DRB Application No.: 07DRB-70310

Project # 1005387

Project Name: NEW MEXICO TOWN CO'S ORIGINAL TOWNSITE OF ALBUQUERQUE NEW MEXICO

# DRB CASE ACTION LOG (PREL/FINAL PLAT)

**PLAT OF
LOT 1-A, BLOCK 28
NEW MEXICO TOWN COMPANY'S ORIGINAL
TOWNSITE OF ALBUQUERQUE, NEW MEXICO
PROJECTED SECTION 20, T. 10 N., R. 3 E., N.M.P.M.
TOWN OF ALBUQUERQUE GRANT
CITY OF ALBUQUERQUE
BERNALILLO COUNTY, NEW MEXICO
OCTOBER 2007
SHEET 2 OF 2**

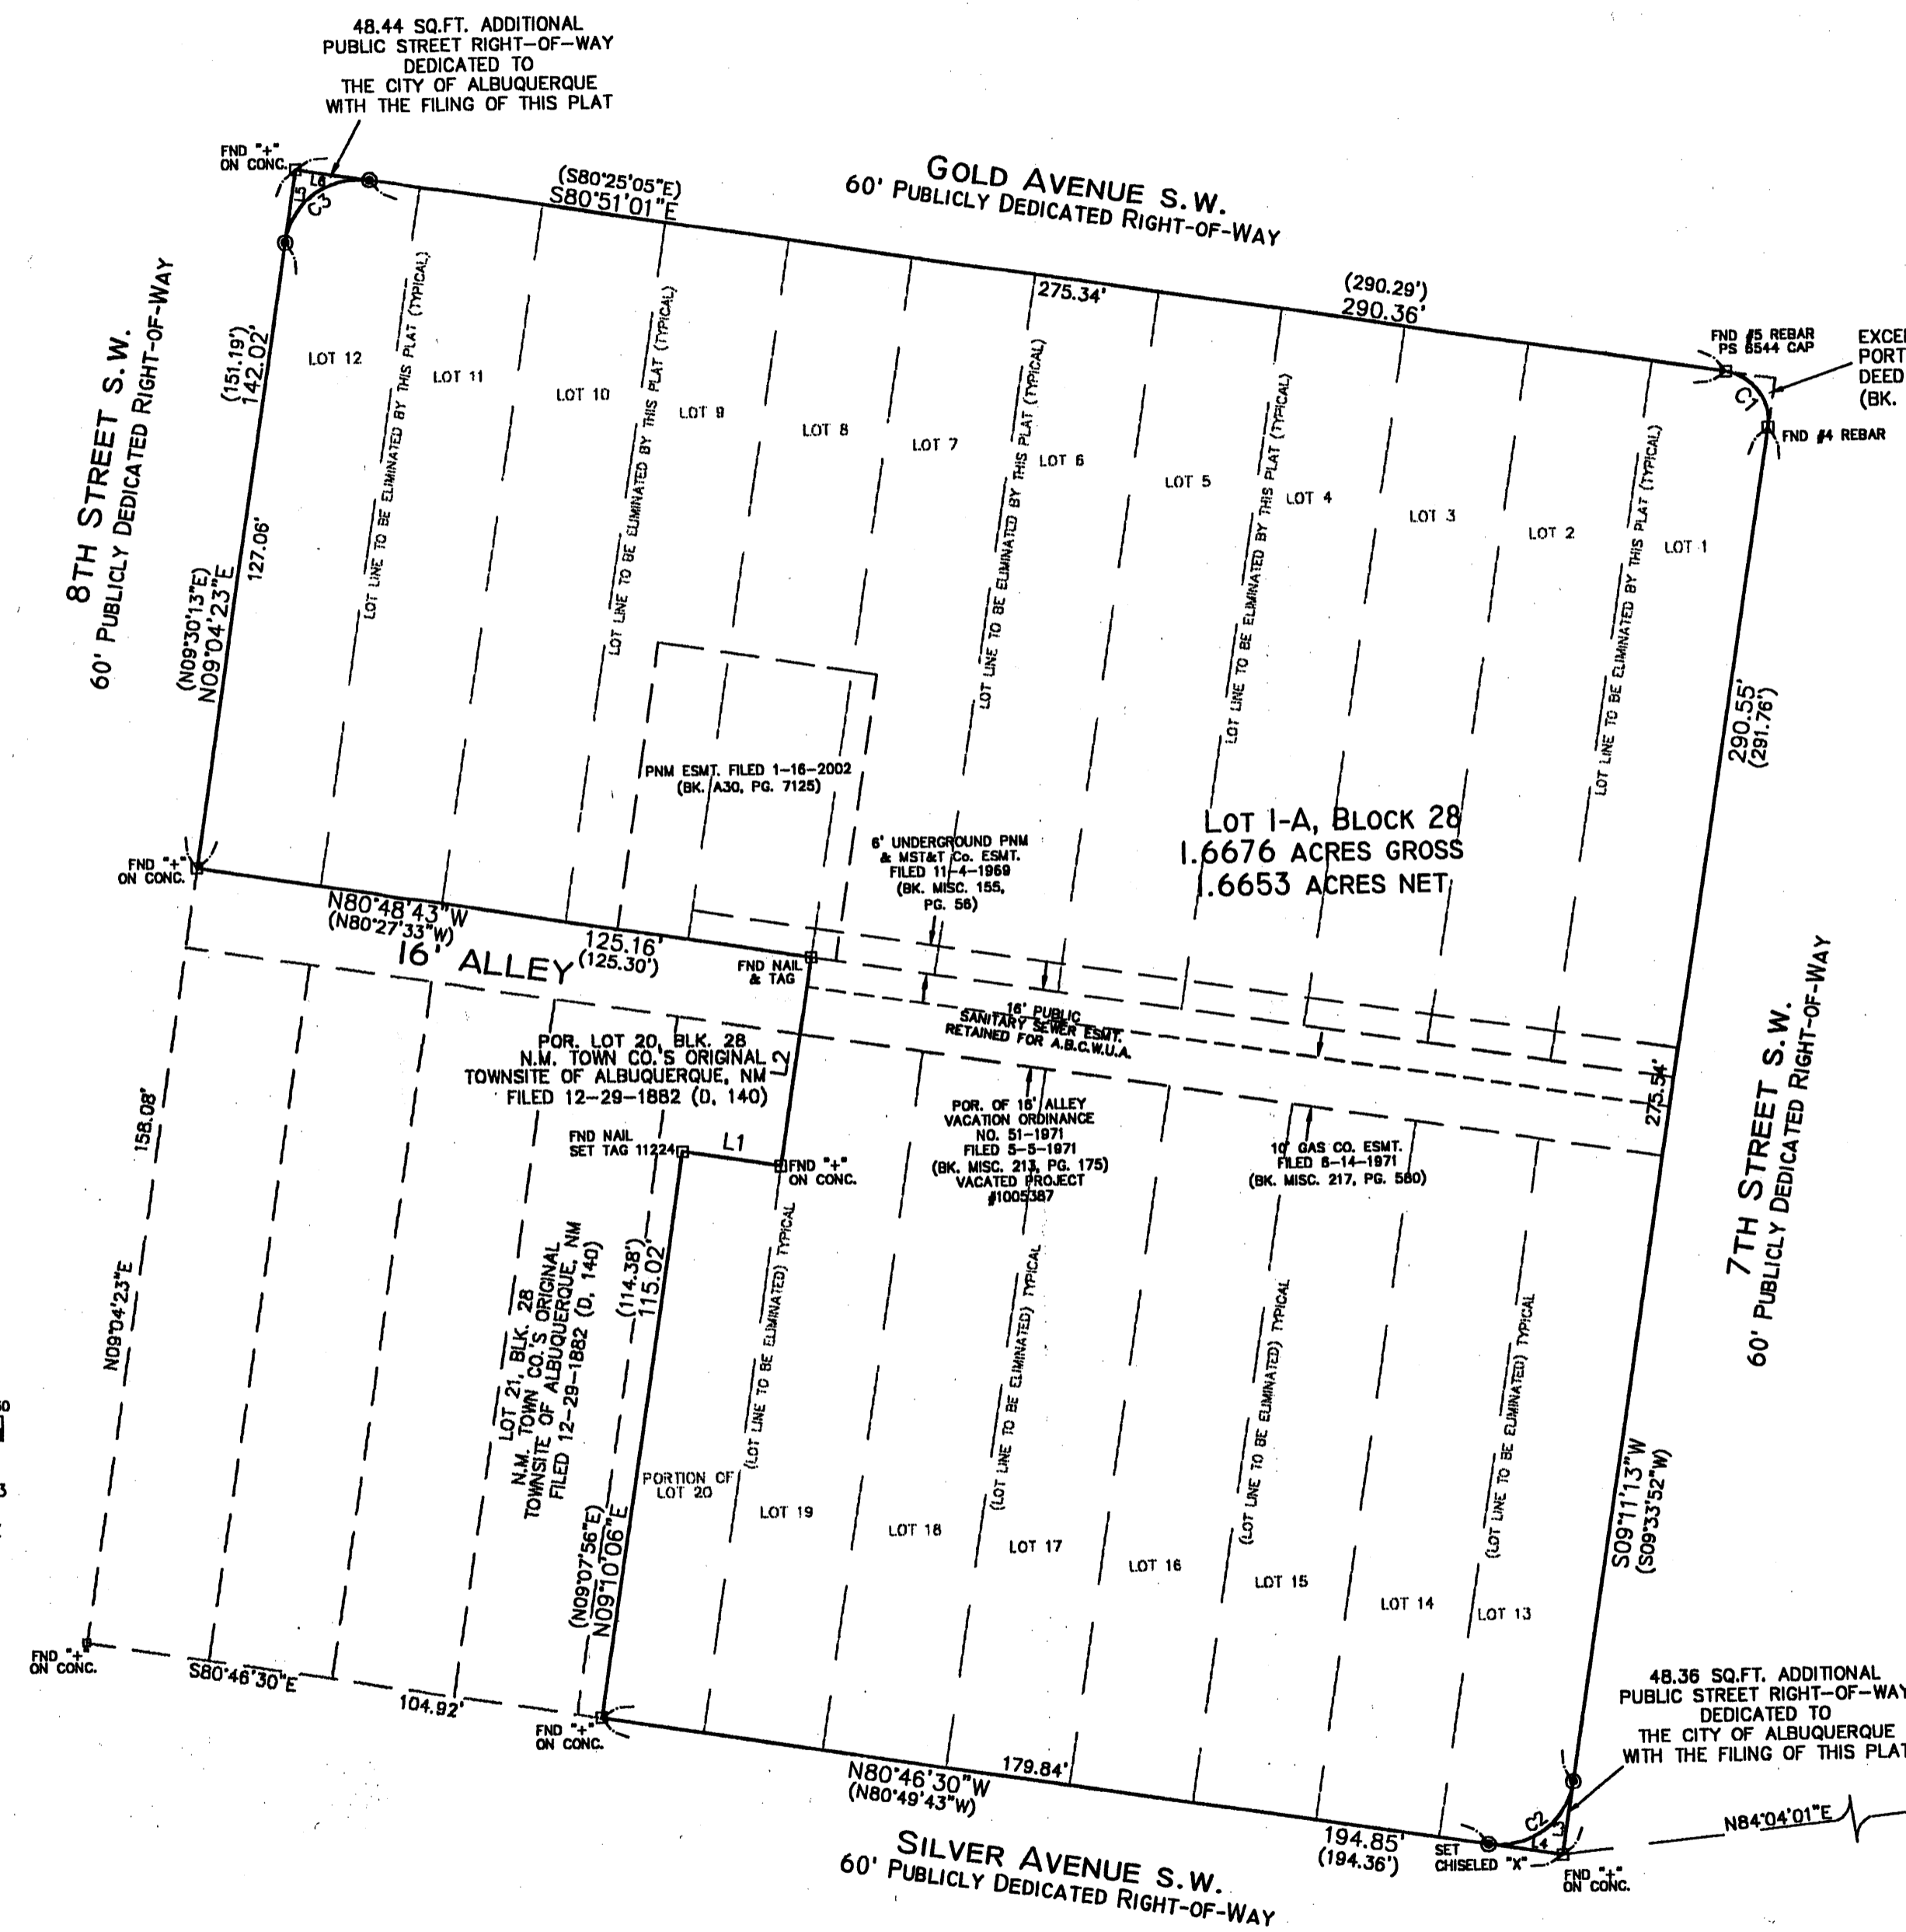
TRANSPORTATION: radius dedication on corners.

PLANNING (Last to sign): radius dedication on corners  
revised AGU dxf  
Copy of deed.
